Heckington Fen Solar Park

EN010123

Appendix 6 – Change consultation information leaflet

Change Notification Consultation– Information Leaflet

- Proposed Order Limits
- AW1
- AW2
- Submitted DCO Order Limits

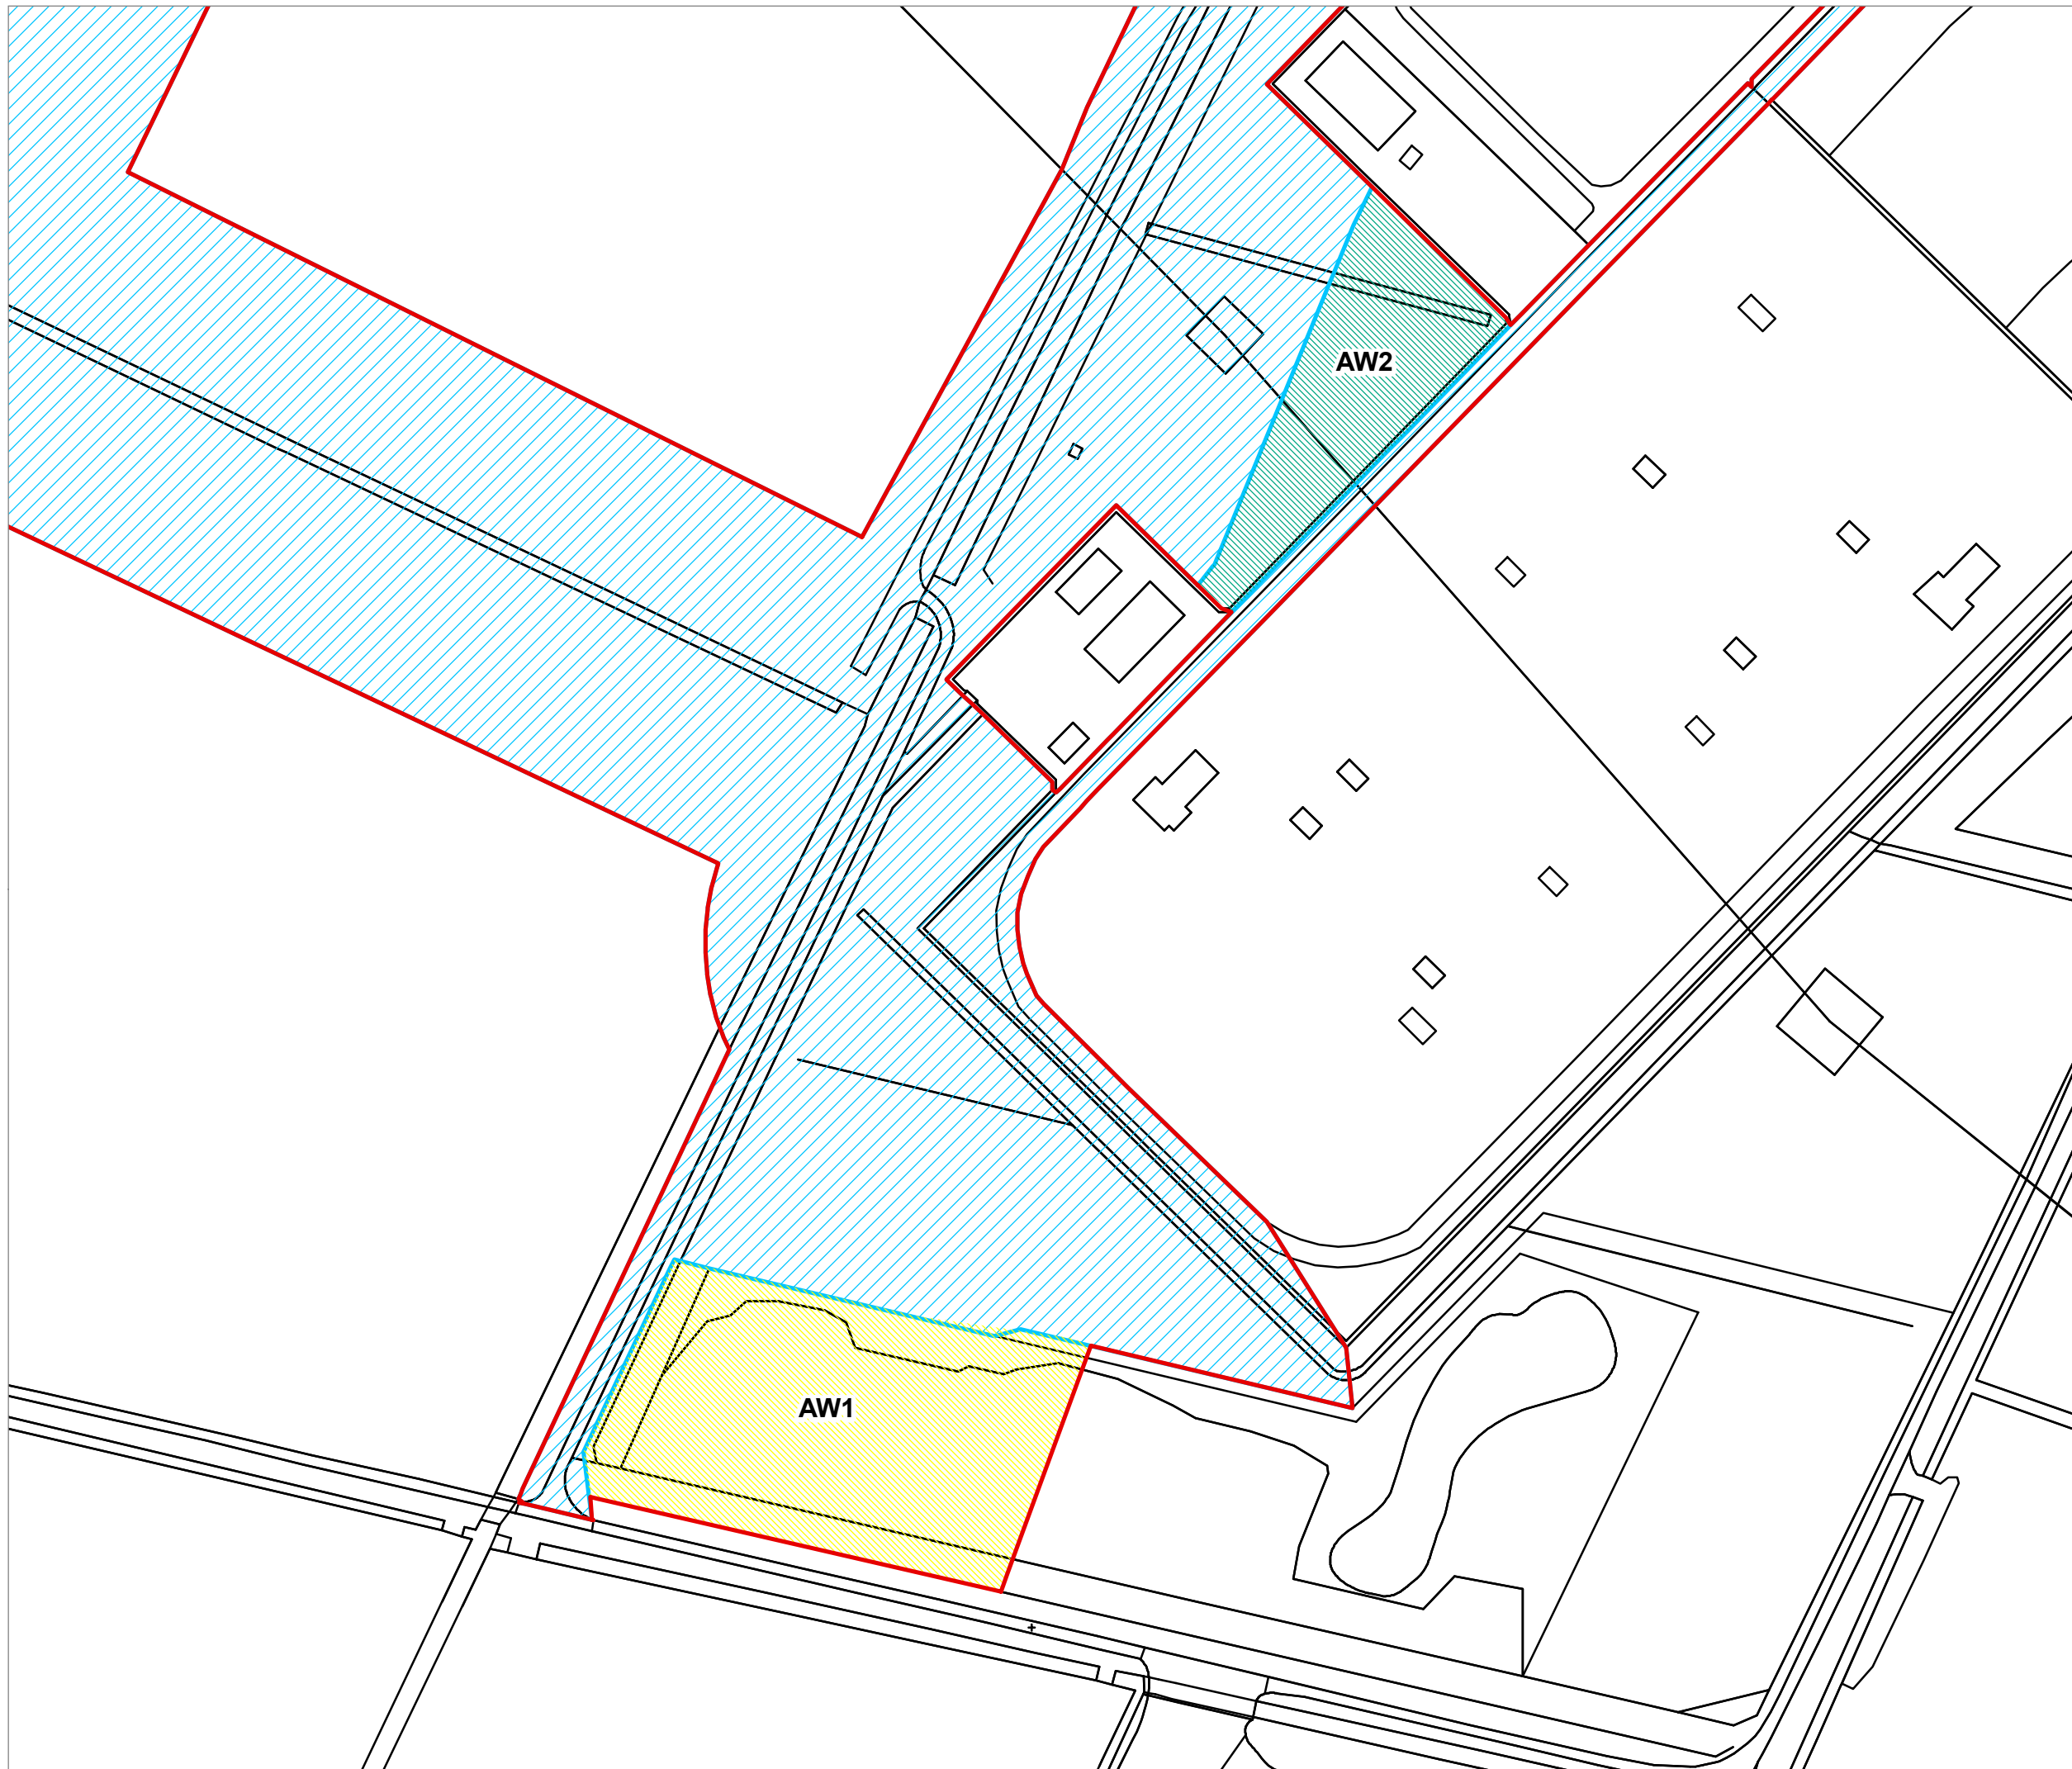
- a new section of NGET infrastructure at the substation comprising a busbar extension including a section breaker, a bus coupler and a feeder circuit on land to the south of Bicker Fen Substation (AW1) ; and
- a new cable sealing end compound (CSE) on land to the west of Bicker Fen Substation (AW2); together known as, the "Additional Works".

Accordingly, a larger area (of approximately 0.9ha) is needed to deliver the Additional Works and to facilitate the Applicant's connection into the Bicker Fen Substation. The full extent of the land area covered by the change is shown in yellow and green hatching on plan overleaf.
